# RESPONSE TO SUBMISSIONS

Taronga Zoo  
Upper Australia Precinct

Prepared for  
**TARONGA CONSERVATION SOCIETY AUSTRALIA**  
9 November 2020

BRADLEYS HEAD ROAD BOUNDARY

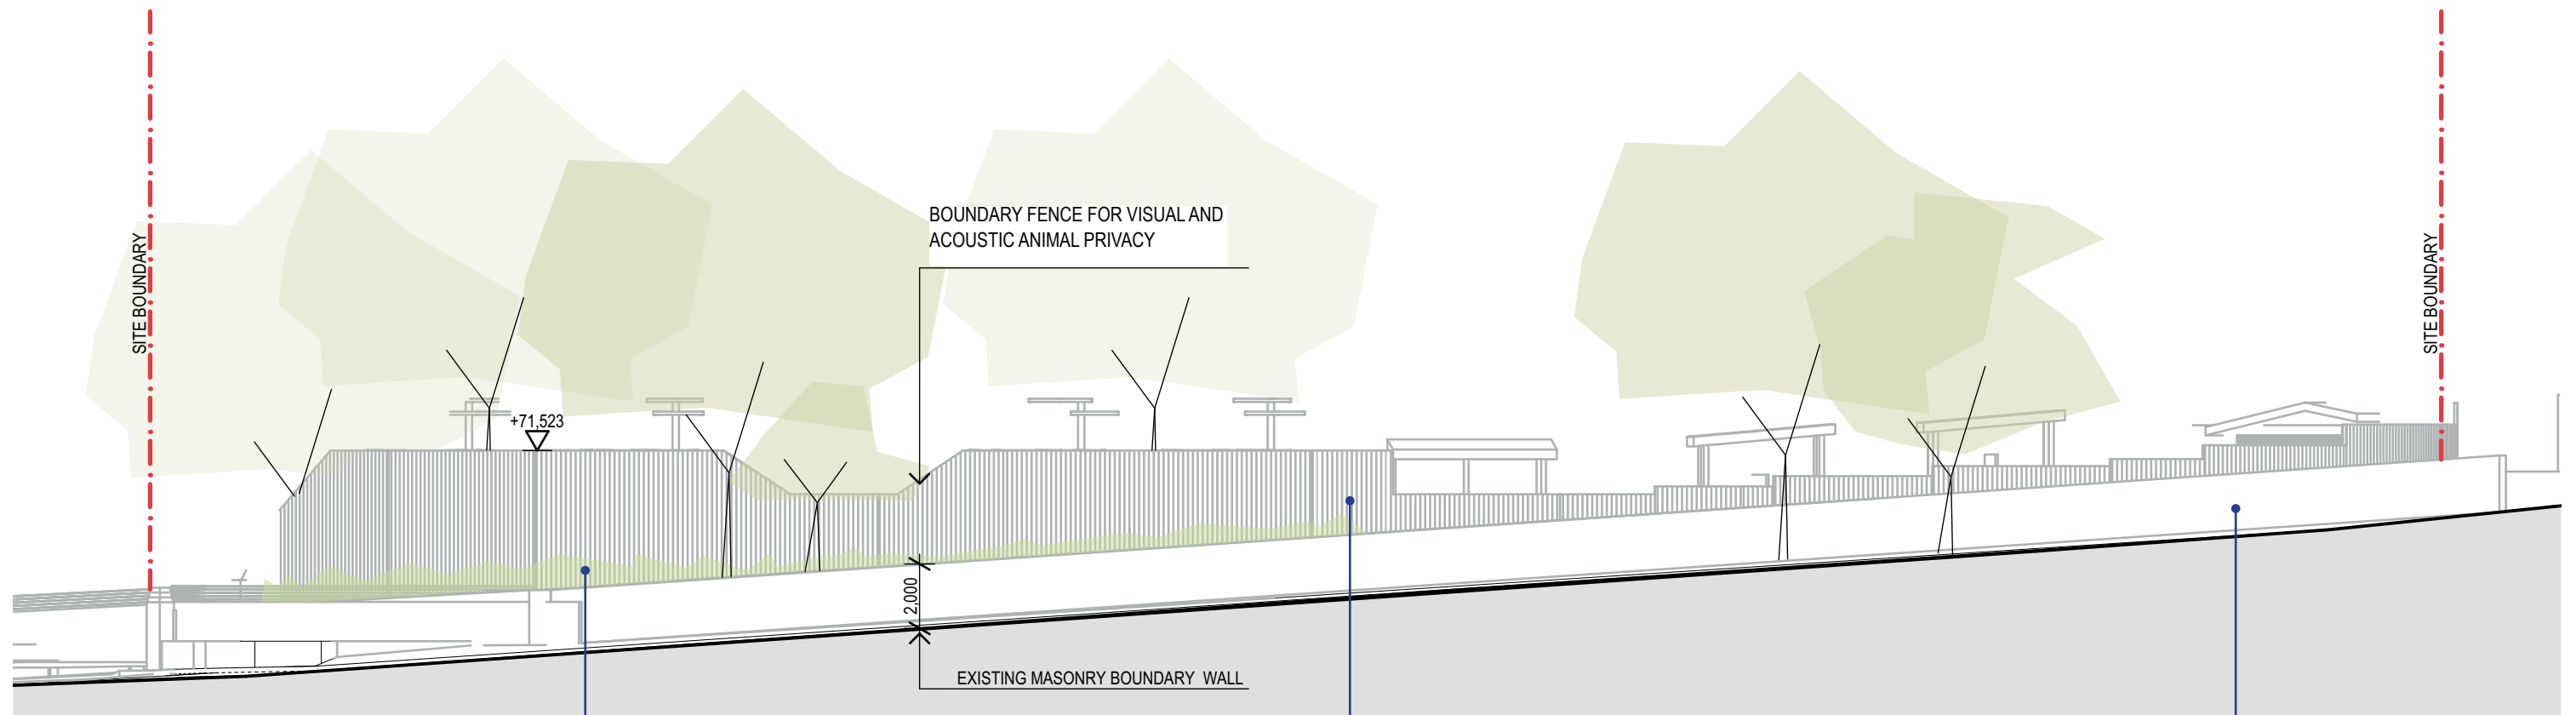
- NSW Heritage Council (HNSW) provided the following comments:
  - HNSW requests further visual information (ie. photomontage and design palate) regarding the interface of the new fencing partition on Bradleys Head Road and the sandstone boundary wall.

- Mosman Council recommends the following conditions of consent:
  - Requirement for landscaping of a sufficient height to be provided in front of fence

Submissions received by Heritage NSW and Mosman Council requested additional details in relation to the new fence on Bradley’s Head Road. Additional information has been prepared by Lahznimmo and Spackman Mossop Michaels (**Appendix A**) to illustrate how the wall relates to the existing masonry wall and the overall landscaping of the area.

The fence has been designed at a certain height for the protection of the animals and provides connections to the overall themes of the Upper Australia Precinct. The location of the fence and additional planting are considered a suitable distance to ensure there are no impacts on the heritage significance of the masonry wall. Mature native plantings including a mix of willow-leaved hakea (*Hakea salicifolia*) and teatrees (*Leptospermum petersonii*) are proposed along the site boundary. Both species will grow between 4-5 metres high with dense foliage to a natural element between the masonry wall and new fence.

The fence material will incorporate cement panels with indicative designs shown on the Materials and Planting Selection plan enclosed in **Appendix A**. The design will be further developed in consultation with an Indigenous art consultant to reflect the landscape character of Bradleys Head and the Australian character of the overall precinct.
